DECISION DELEGATED TO HEAD OF PLANNING
DECISION DELEGATED TO HEAD OF PLANNING

Application No:	H04-0199-24	Applicant:	Cowley Academy
Proposal:	Replacement windows and internal alterations (drama block) and new fence along east elevation of drama block		
Location:	Thomas Cowley High School School Lane Donington		
Terminal Date:	17th January 2025

DRAWN BY EK	CHECKED BY EMA	DATE February 2024
SCALE 1:100 @ A1	PROJECT NUMBER 2404	
DRAWING NUMBER PP100	REV 04

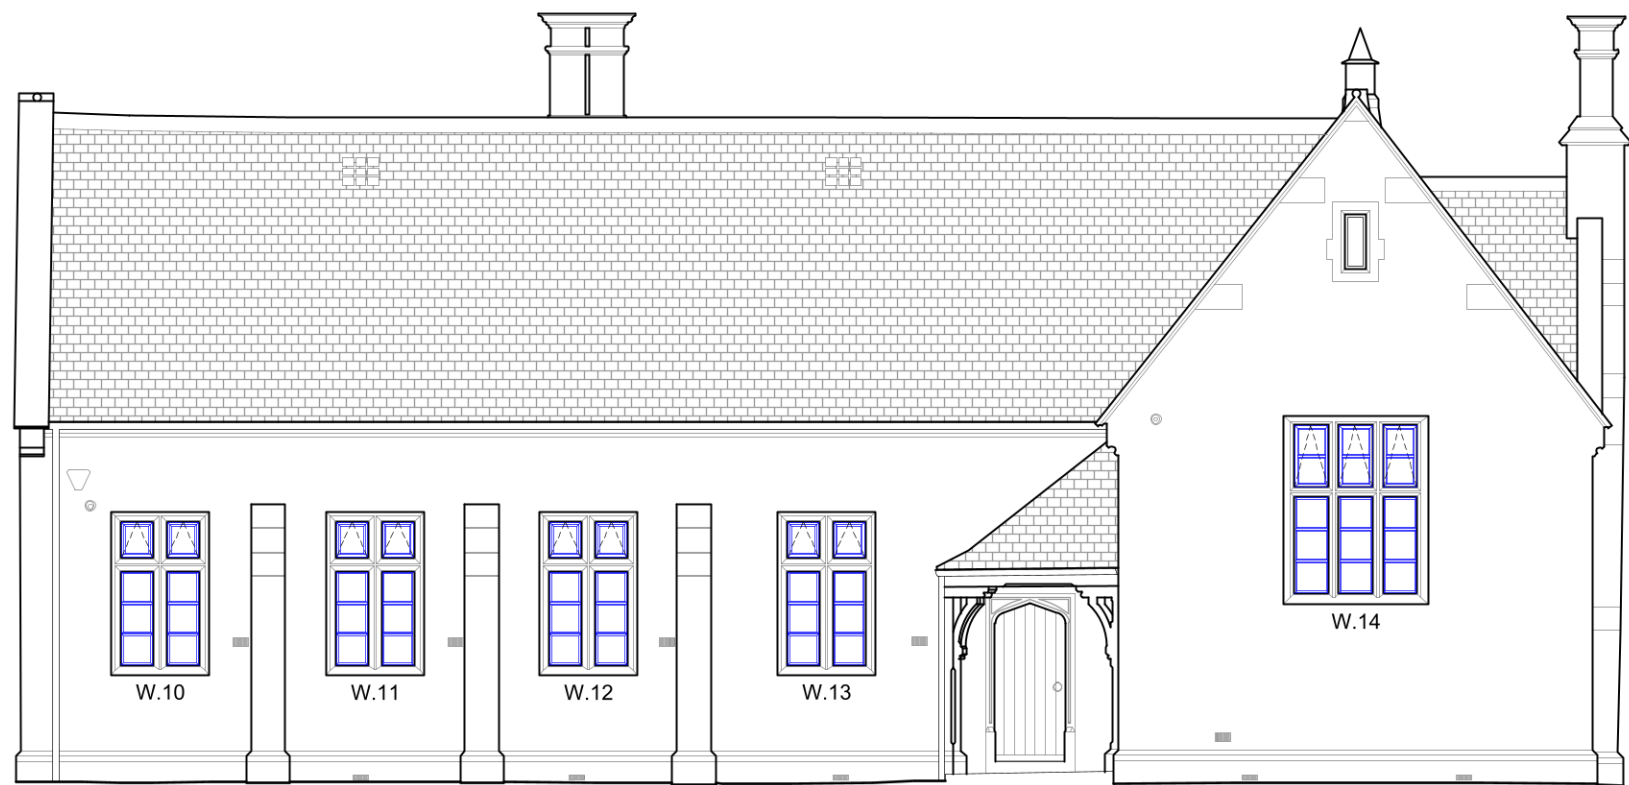
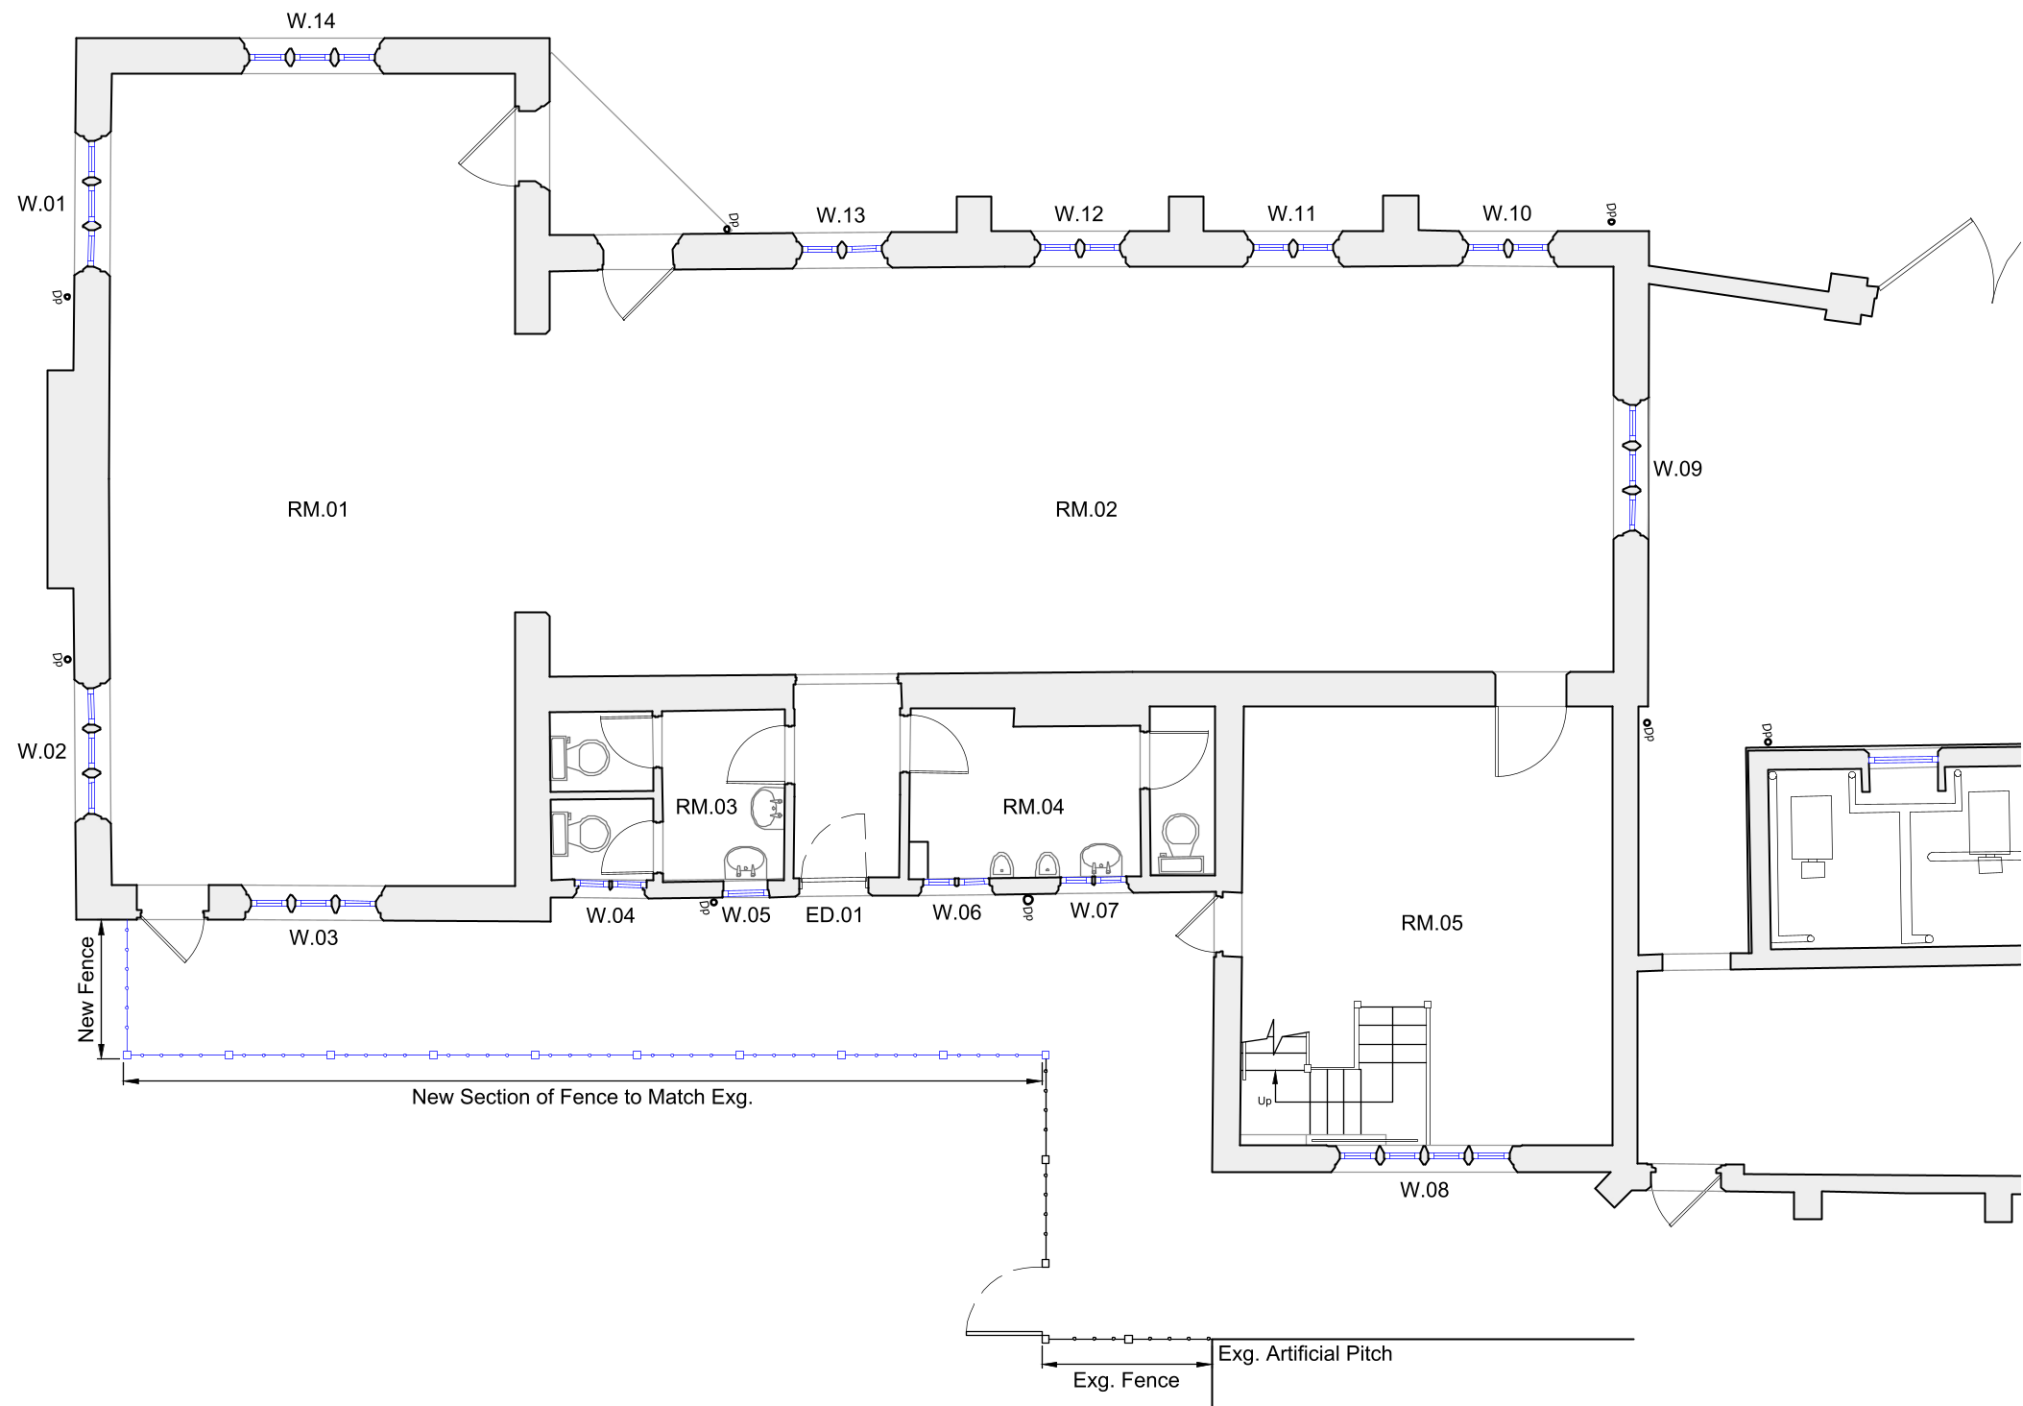
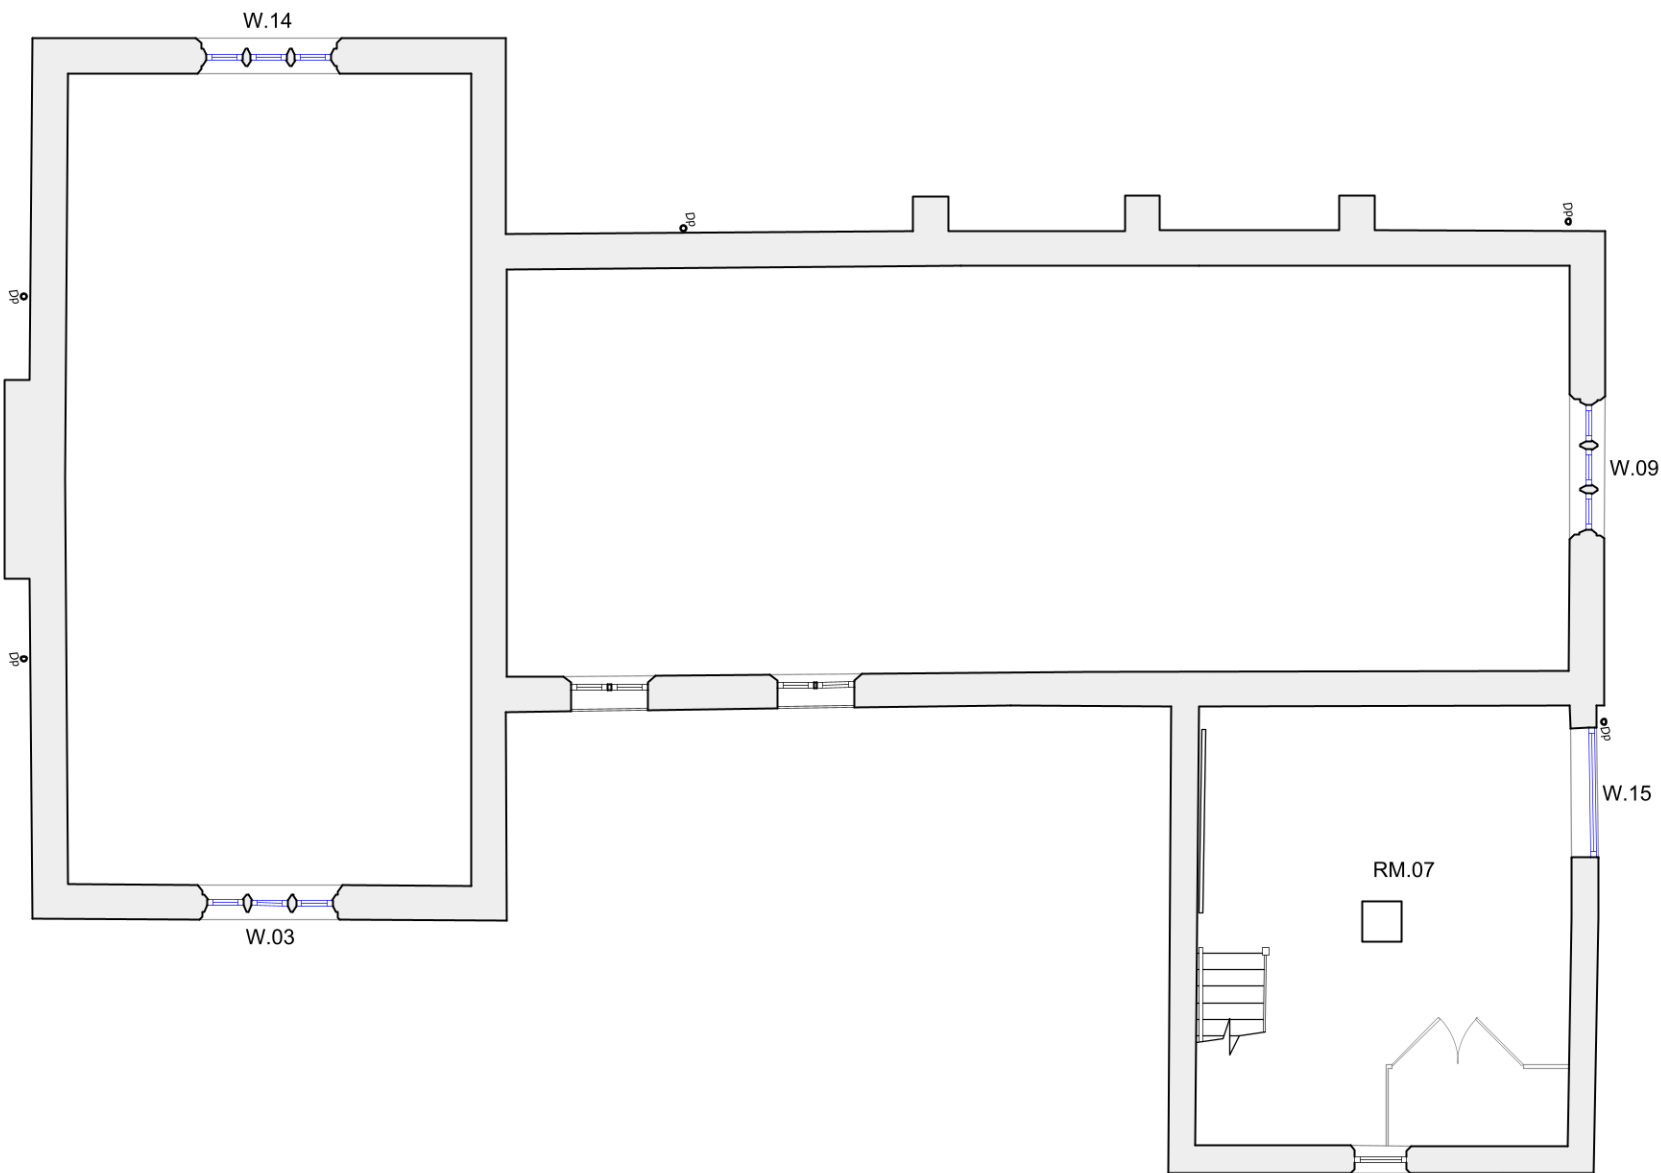
Historic England responded initially to the proposal by objecting to two aspects of the proposed development; those being that the proposed windows with overlapping openings would fail to replicate the original style and most particularly, that the proposed dry lining of the interior would strip the interior of its value.

In assessing the proposed development, it is clear that the proposal to replace historic metal framed, single glazed windows with modern aluminium framed double glazed units is a form of harm, in that they do not seek to retain this historic feature, and utilise non-original features such as the modern double glazing and a greater quantity and mass of glazing bars. Given the prominence of the building in the historic environment and the scale of the change to the fenestration throughout, the LPA considers this form of harm to be classified as 'substantial Harm' in accordance with Para. 212 of the NPPF.

Returning to the assessment of the proposed windows, whilst the scale of change is substantial and therefore, the works have been classified as 'substantial harm', in and of themselves, the proposed windows are not particularly stylistically inappropriate to the building. A greater mass of glazing bars is included, but this is not wholly alien to the host structure's architectural period. This means that the only truly inappropriate aspect of the proposed windows is the double glazing, and as such, the proposed windows should only be considered harmful in comparison to the extant form on site, not necessarily harmful in their own right. Ultimately, then, whilst the works undoubtedly amount to 'substantial harm', the true scale of that harm is perhaps lesser than this classification may suggest at face value.

The applicant amended the proposal to remove the proposed interior alterations.

Historic England responded confirming they were satisfied with the positive nature of the proposed change, and confirmed withdrawal of formal objection, leaving the assessment of the case to the

With this in mind, the above justification and public benefit is accepted by the LPA and is considered to be substantial enough to outweigh the harm.
